DECISION DELEGATED TO HEAD OF PLANNING

Application No:	H17-0811-22	Applicant:	Ashley King Developments Ltd
Proposal:	Details of archaeological investigation, flood risk assessment and drainage strategy measures, proposed boundary treatments, publicly accessible open space, protected species report, open space management plan, storage and disposal of refuse and recycling, protection of trees, protection of existing hedge, swift nest bricks/boxes, external materials, Sunnydale Close access, gas and electricity external boxes, construction management, estate road phasing and completion plan, surface water disposal and design & location of road/footpath lighting. (Conditions 3, 4, 6, 7, 8, 9, 10, 11, 12, 13, 14, 15, 16, 17, 18, 19, 20, 21 and 22 of H17-1187-21)		
Location:	Land Off Sunnydale Close Surfleet Spalding		
Terminal Date:	20th January 2023

CONDITION COMPLIANCE. Details of archaeological investigation, flood risk assessment and drainage strategy measures, proposed boundary treatments, publicly accessible open space,

SECTION A-A
SCALE 1:100

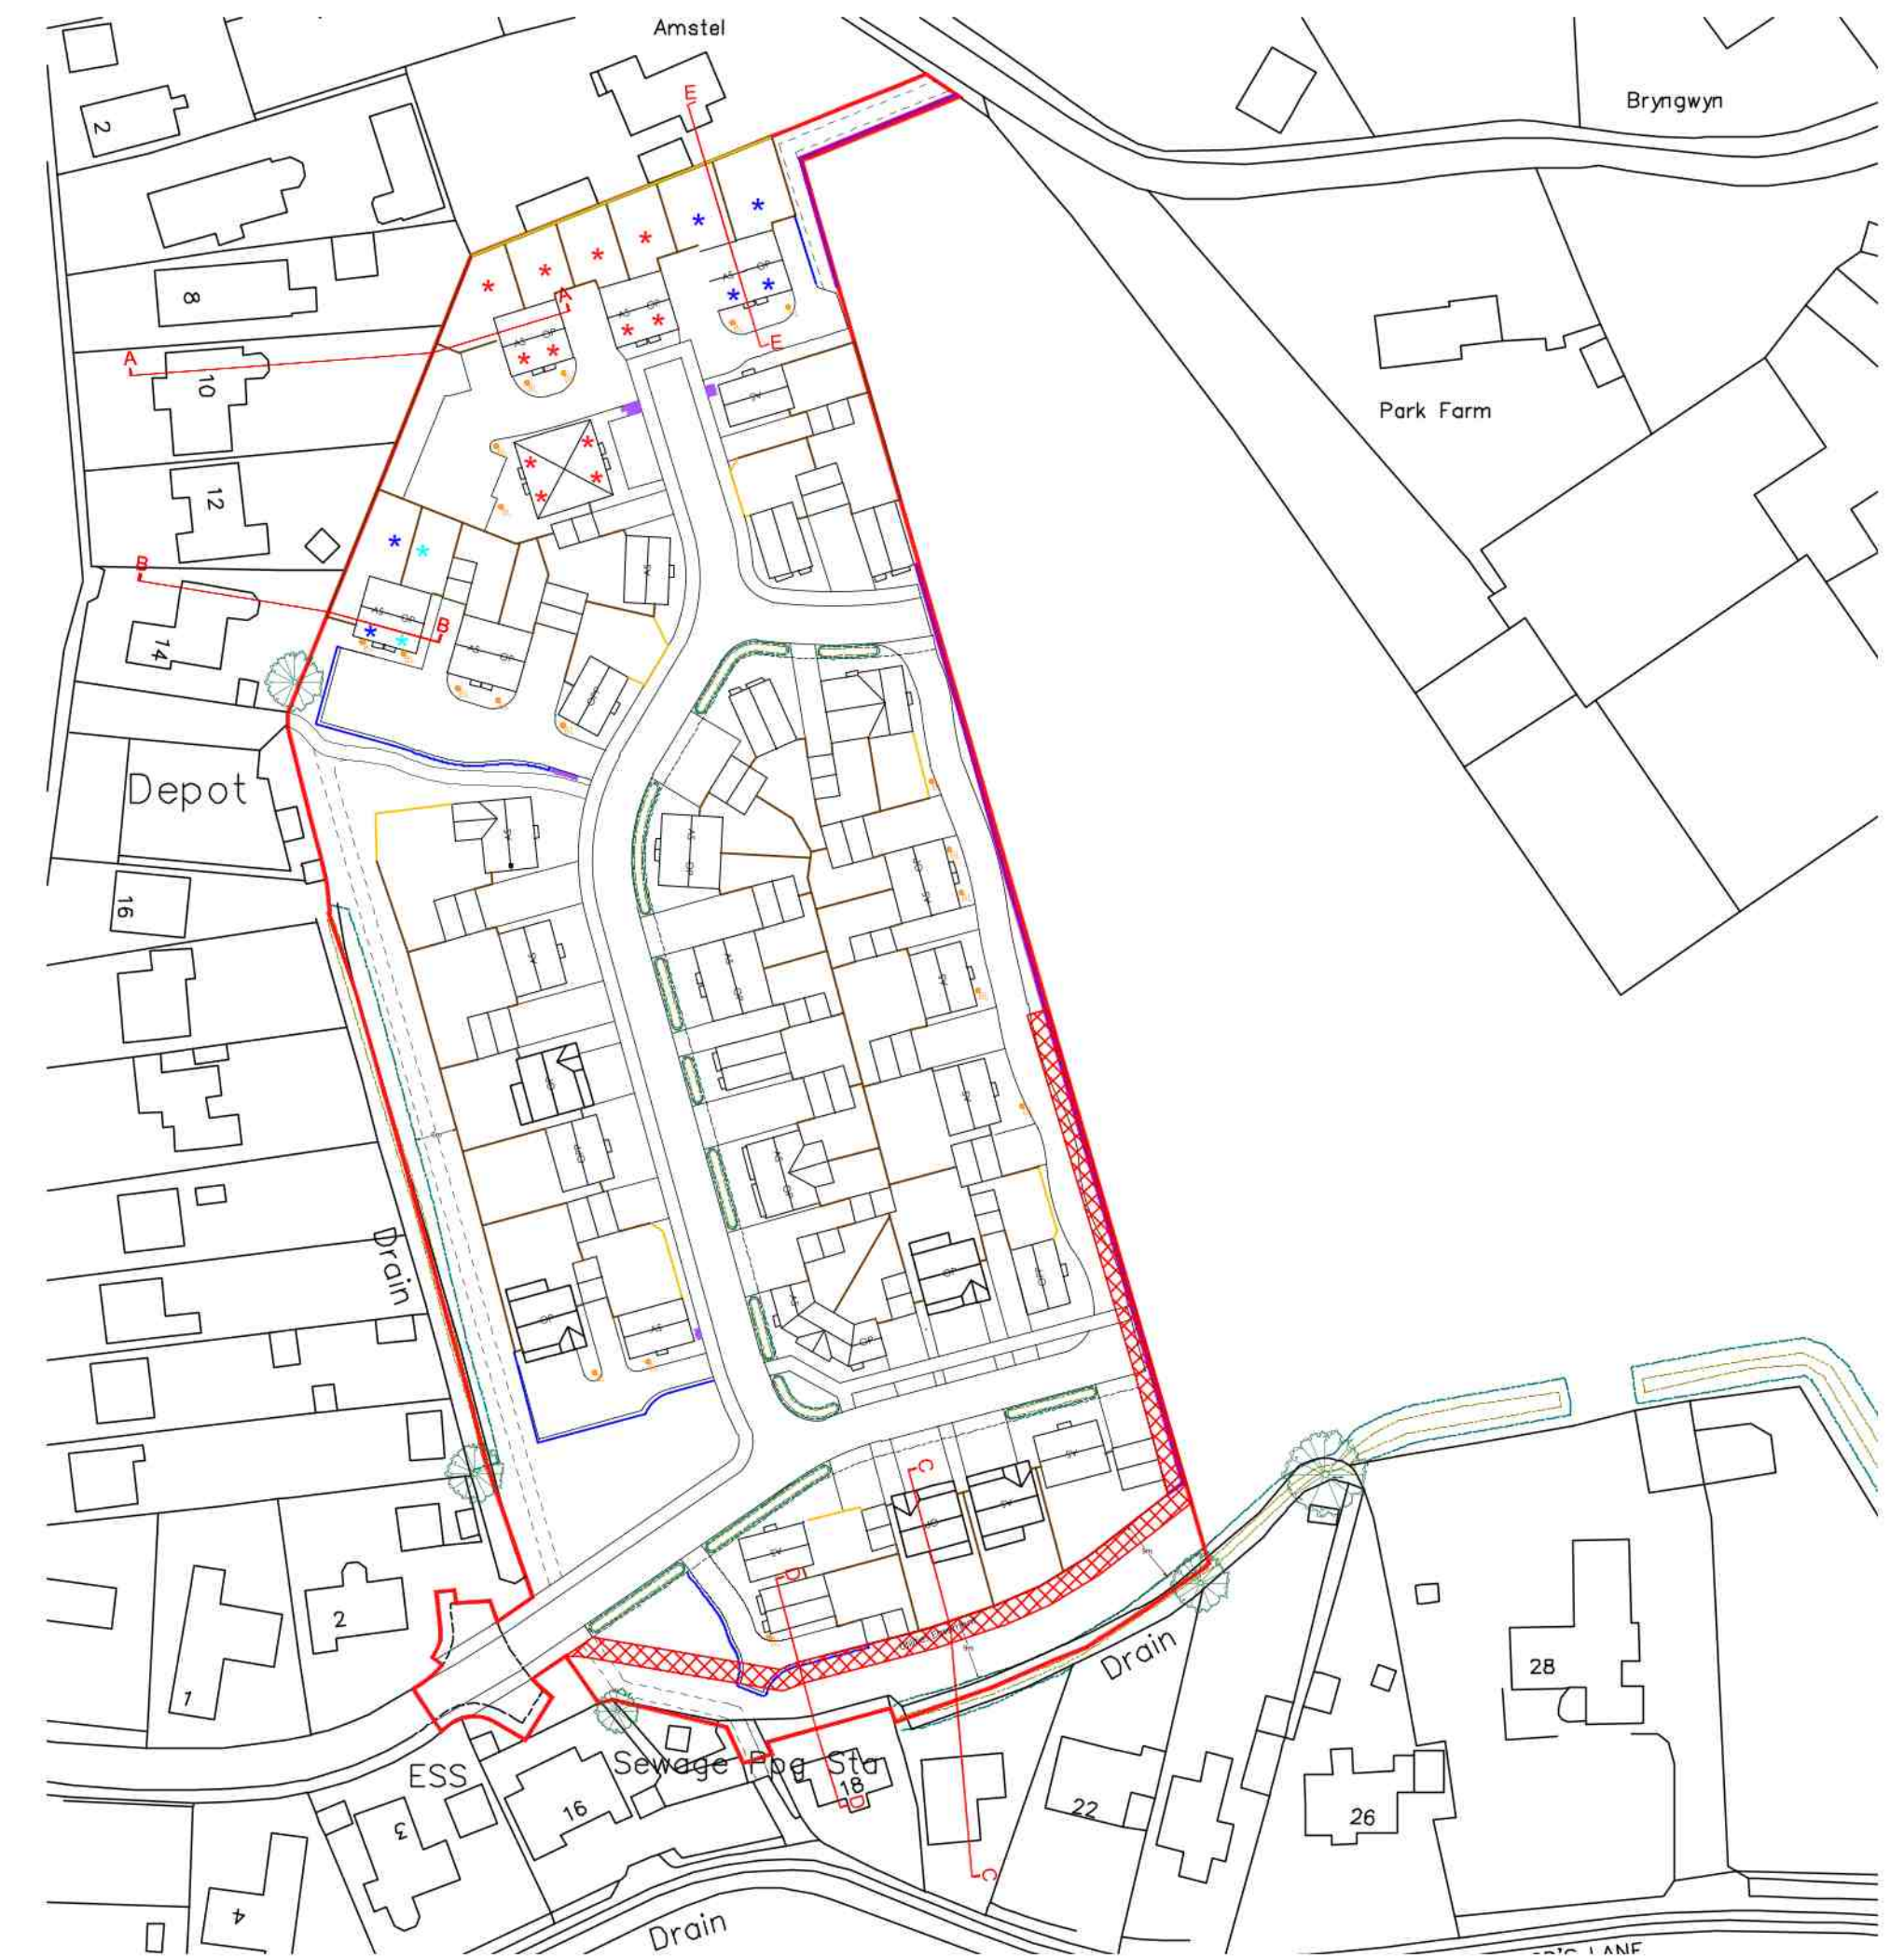
It can be seen from the sections through the edges of the development that this is another site that is to be raised above adjacent existing development - presumably to mitigate against fluvial/coastal flood risk.

Whilst the purpose of producing these drawings is presumably to illustrate any potential for the new properties to overlook existing neighbouring properties, they also highlight the potential for surface

water run-off to be cast from the development onto what will become lower-lying neighbouring properties.

It is therefore requested that physical measures are put in place, wherever the development abuts existing residential properties, to intercept and dispose of any surface water run-off so that the development does not increase surface water flood risk to those neighbouring properties.

Thank you for your notification of receipt of amended details for this Application that show the arrangements to be put in place for the interception of any boundary surface water run-off from the proposed development to prevent it being cast onto existing residential properties adjacent to the site. I can confirm approval of these proposals on behalf of the lead local flood authority.

DRAWING No: 118-BDP-01

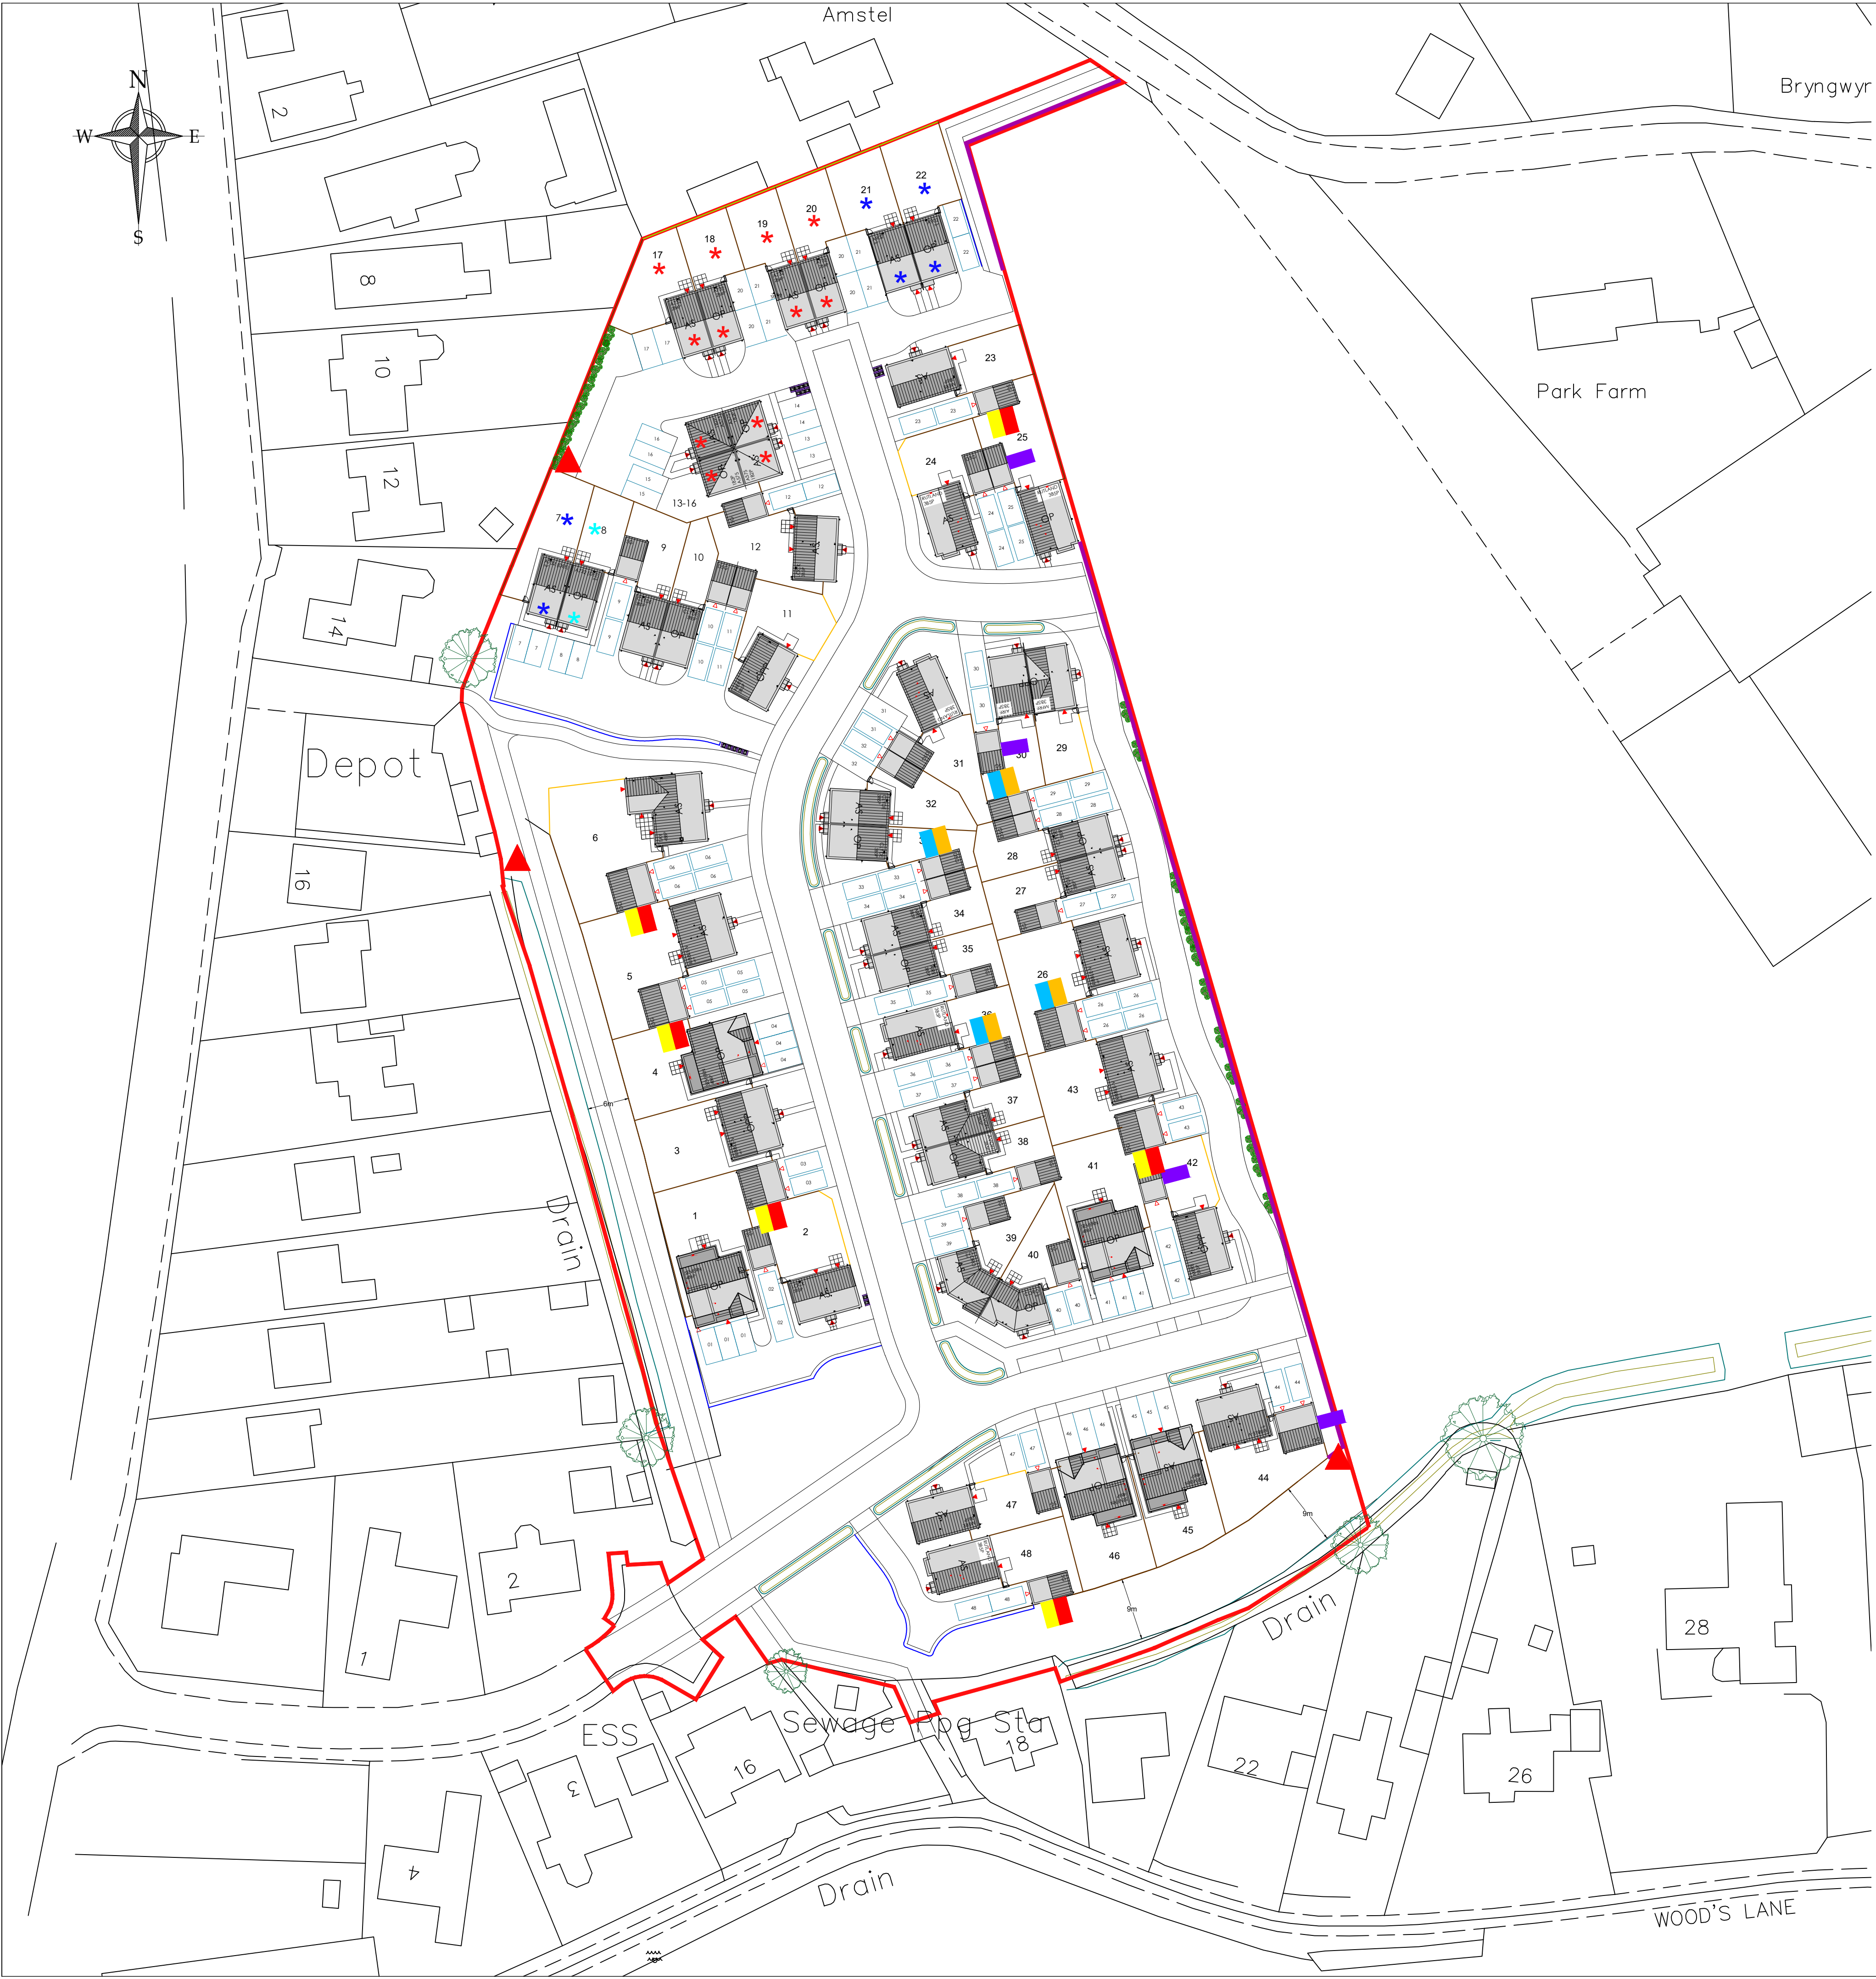
Biodiversity Plan 118-BDP-01 - Depending on the future of the adjoining land, could potentially require south eastern hedgehog box re-situating. All hedgehog boxes must be as far as possible from roadways.
